**DRB CASE ACTION LOG (PREL & FINAL PLAT)**

Project Name: **MONTGOMERY HEIGHTS**

**PROJECT # 1004768 APPLICATION # 06-00369**

**RE: Montgomery Heights/p&f**

**DESCRIPTION**  
 LOTS 1, 2 AND 18, BLOCK 11, MONTGOMERY HEIGHTS,  
 SECTION 3, T.10N., R.3E., N.M.P.M.  
 CITY OF ALBUQUERQUE NEW MEXICO,  
 RECORDED 6/05/52, IN BOOK D1, FOLIO 54.

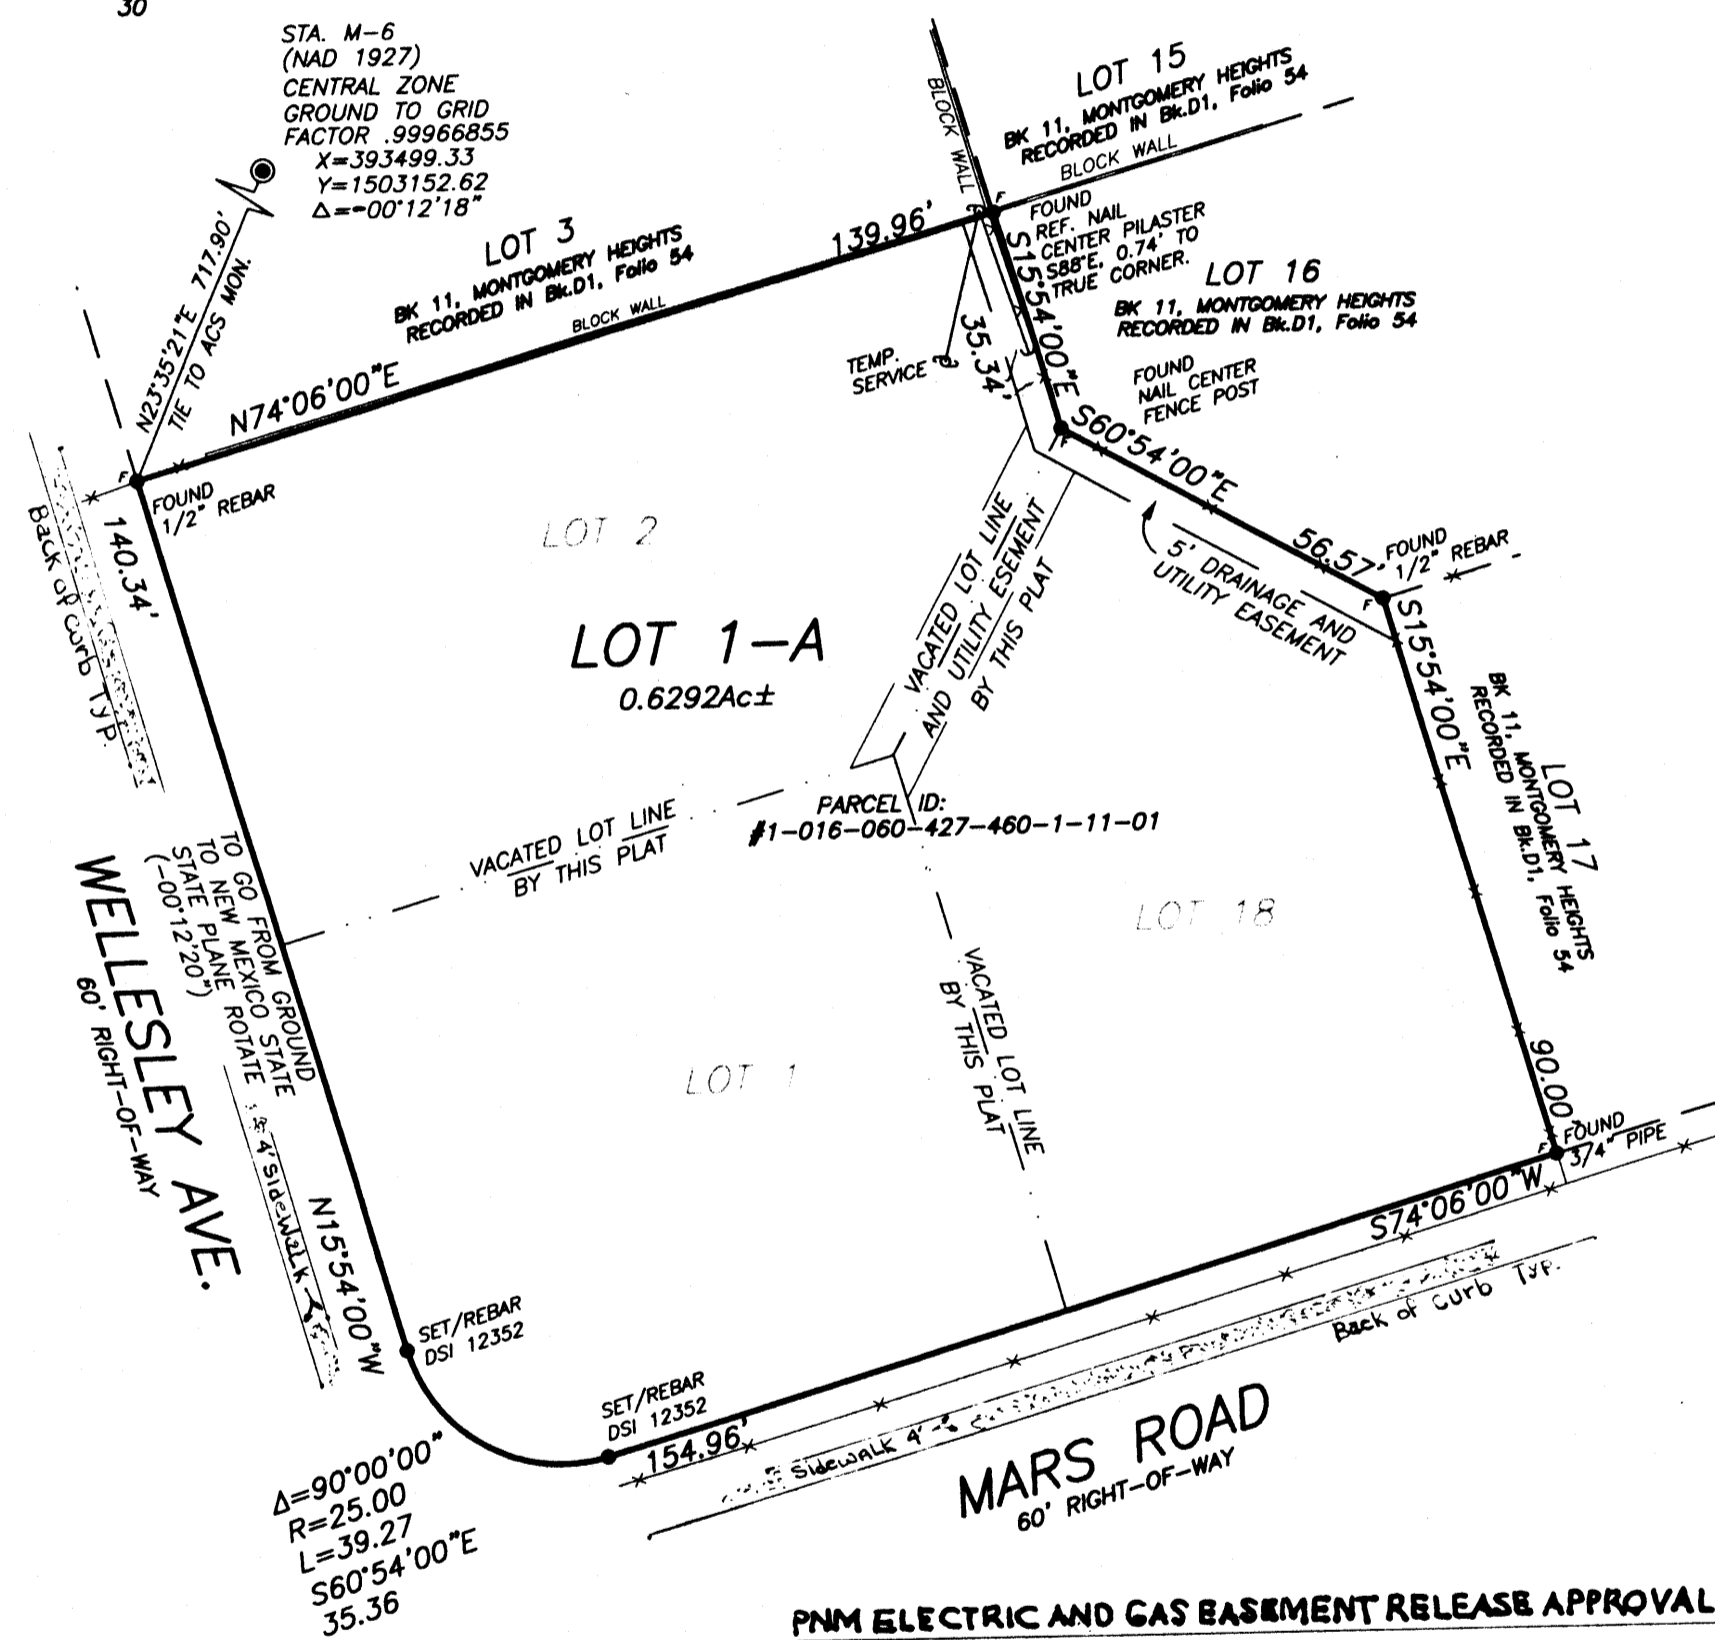
Must vacate PUE thru the DRB vacation process.

The plat shows a vacated utility easement to be vacated with this plat. There is no vacation action requested. What type of utility easement is it?
